CITY OF ALBUQUERQUE

August 3, 2021

Re: OSH MONTANO ROAD
333 Montano Road NW
Traffic Circulation Layout
Engineer's/Architect's Stamp 7-30-21 (F14-D023)

Sheet Title
TRAFFIC CIRCULATION LAYOUT
Scale: As indicated
Drawn: JED
Project No.: 064559810
Sheet No.: **C201**

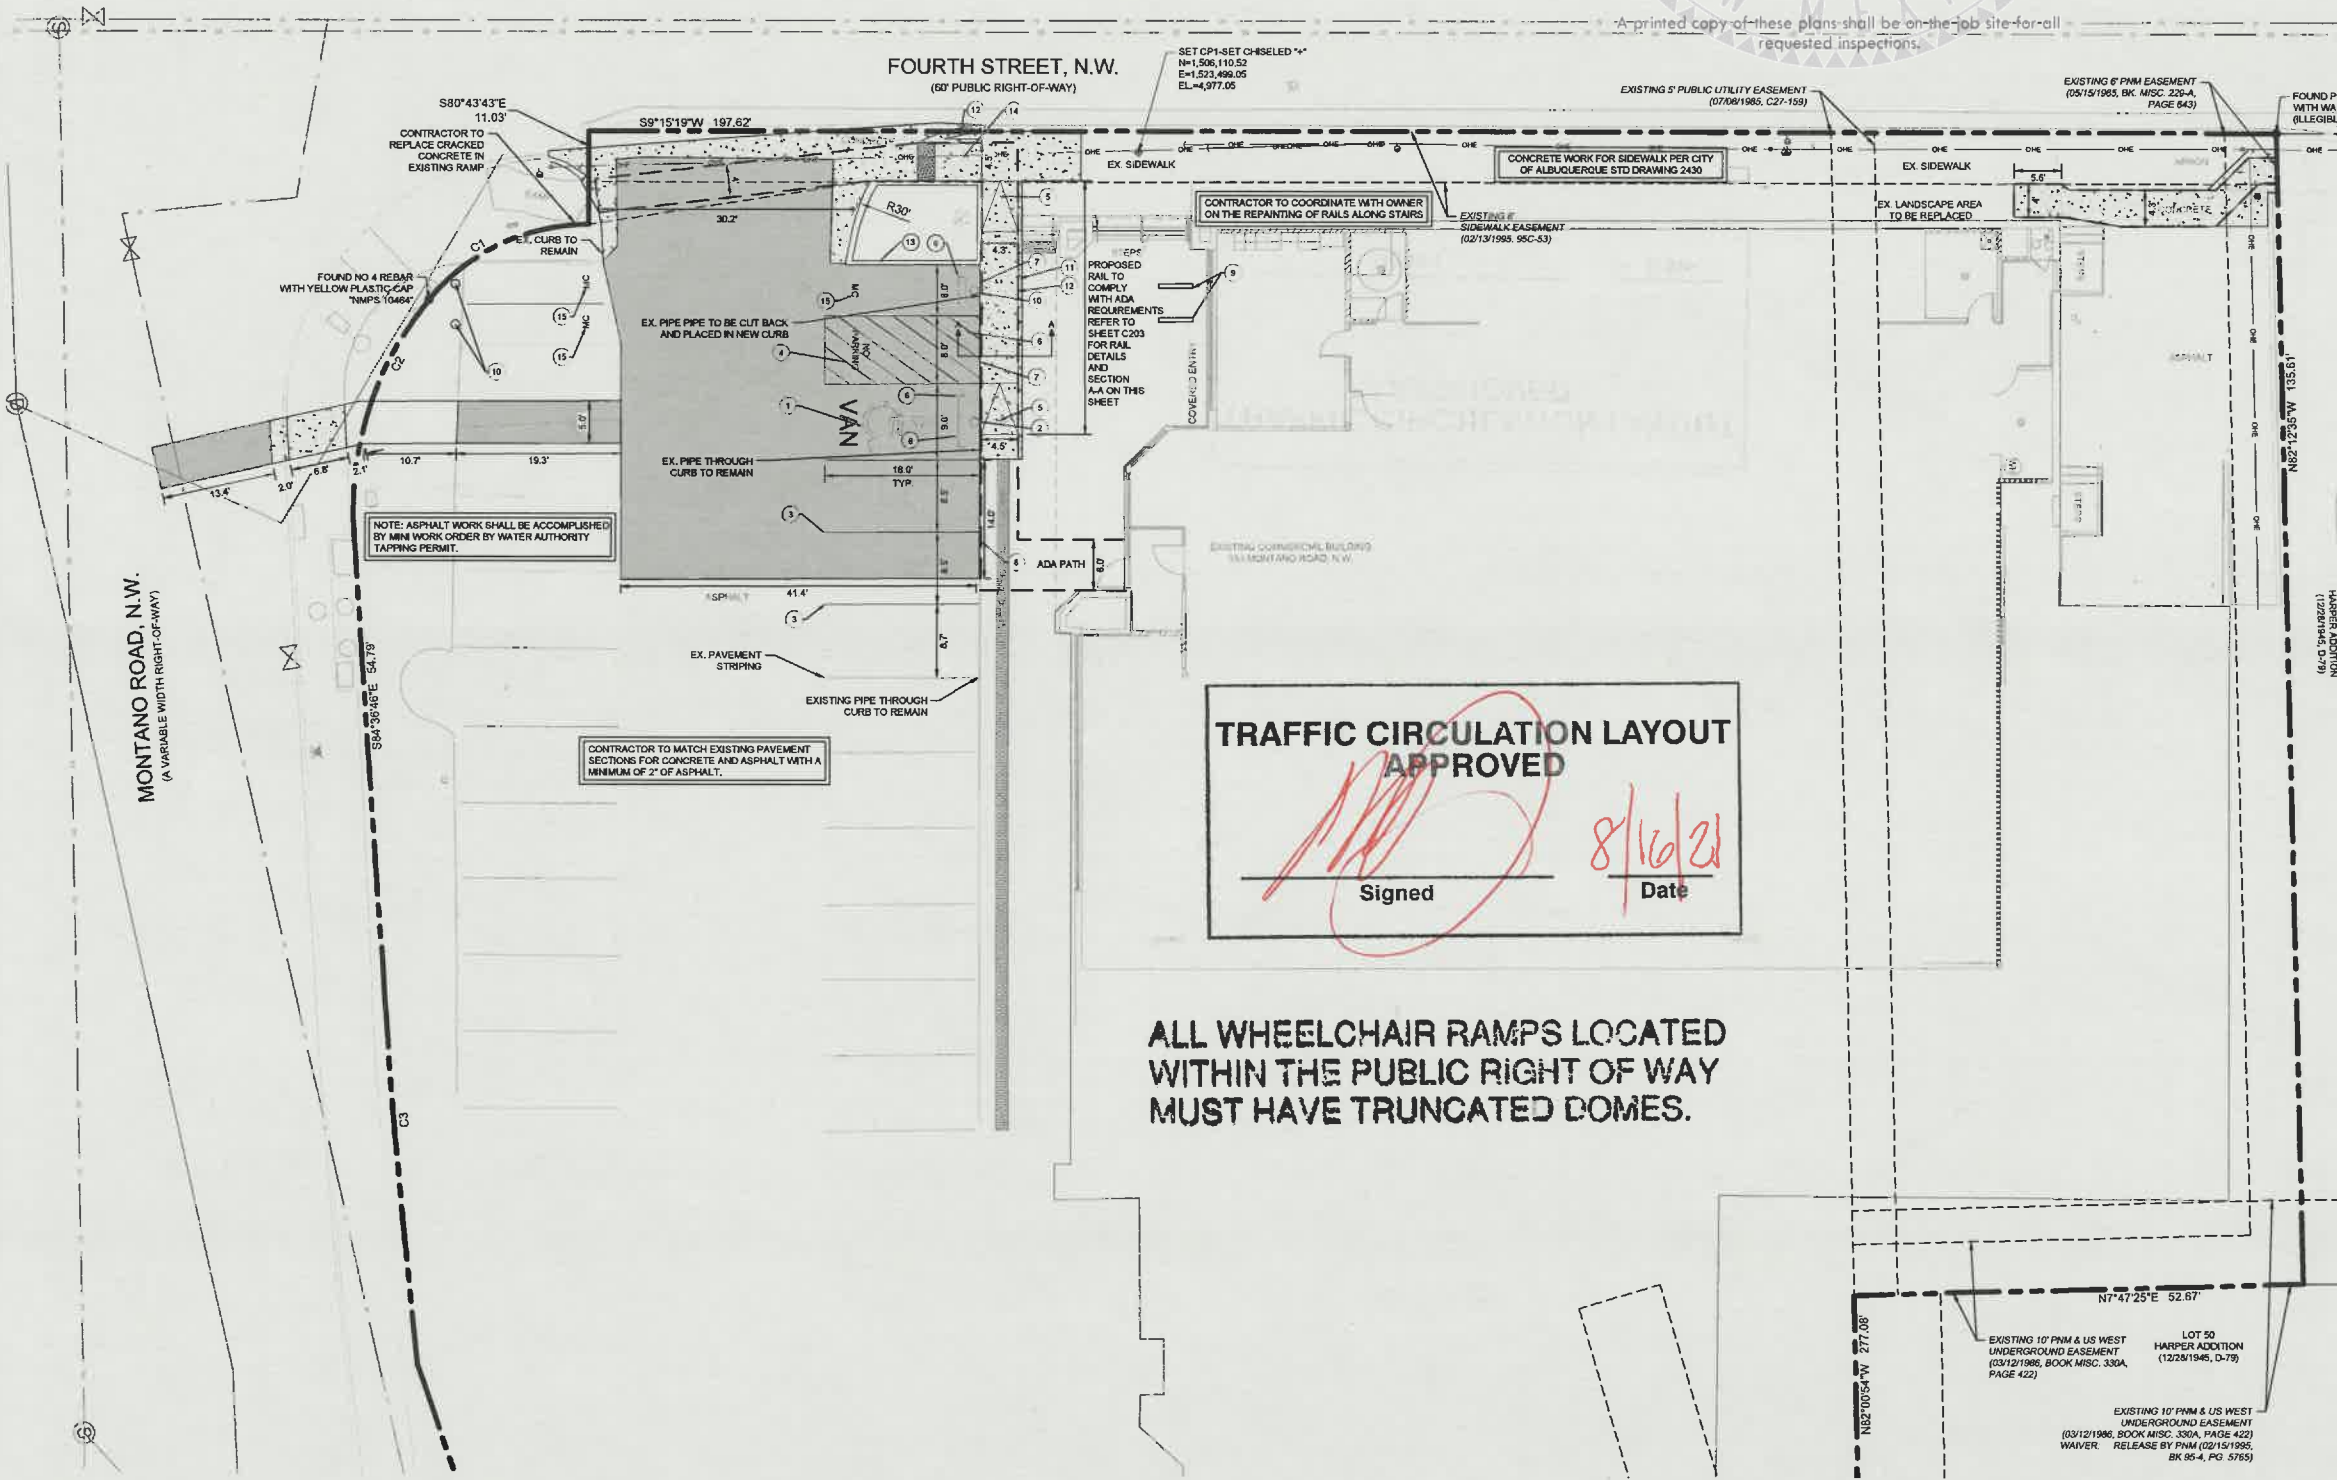
2. **Sheet C201 (Montano Road shaded area):**

- Shown is a shaded area (5ft x 13.4 ft) on Montano Road labeled as asphalt pavement work should read **Asphalt work shall be accomplished by mini work order by Water Authority tapping permit.**** **NOTE ADDED**

C203

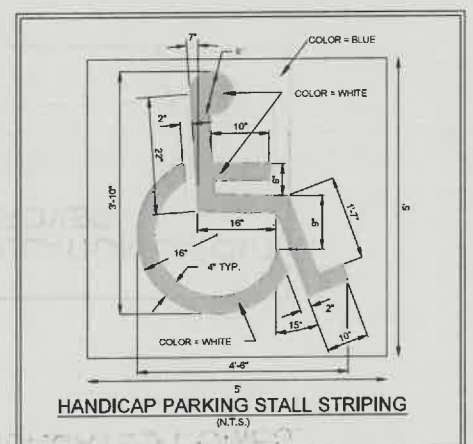
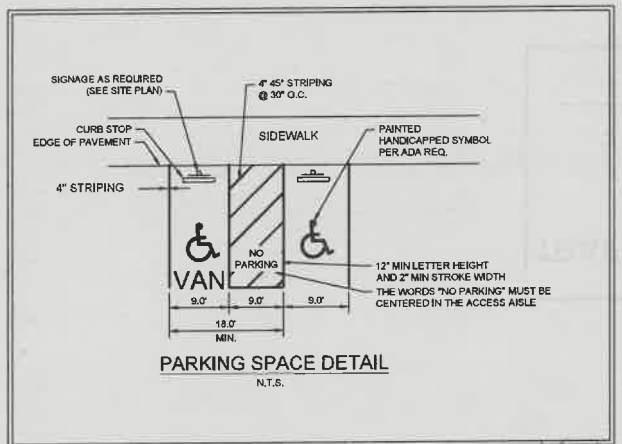
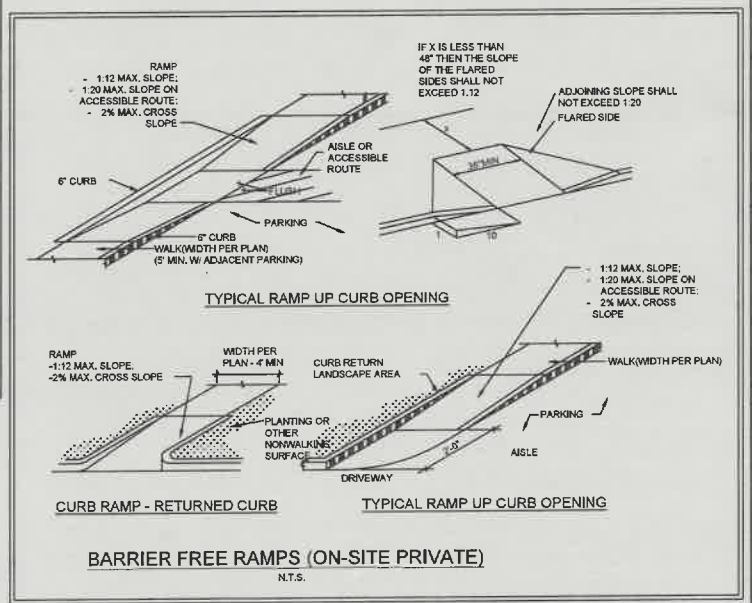
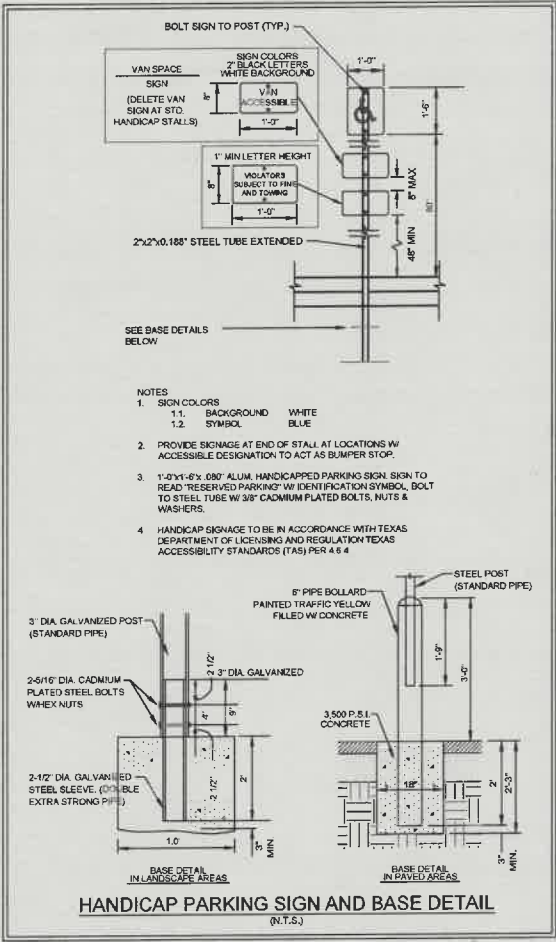
4. **Proposed Handrail (sheet C203-Handrail on Pavment detail):** Show the 4 inch plate at bottom of handrailing. **PLATE ADDED**
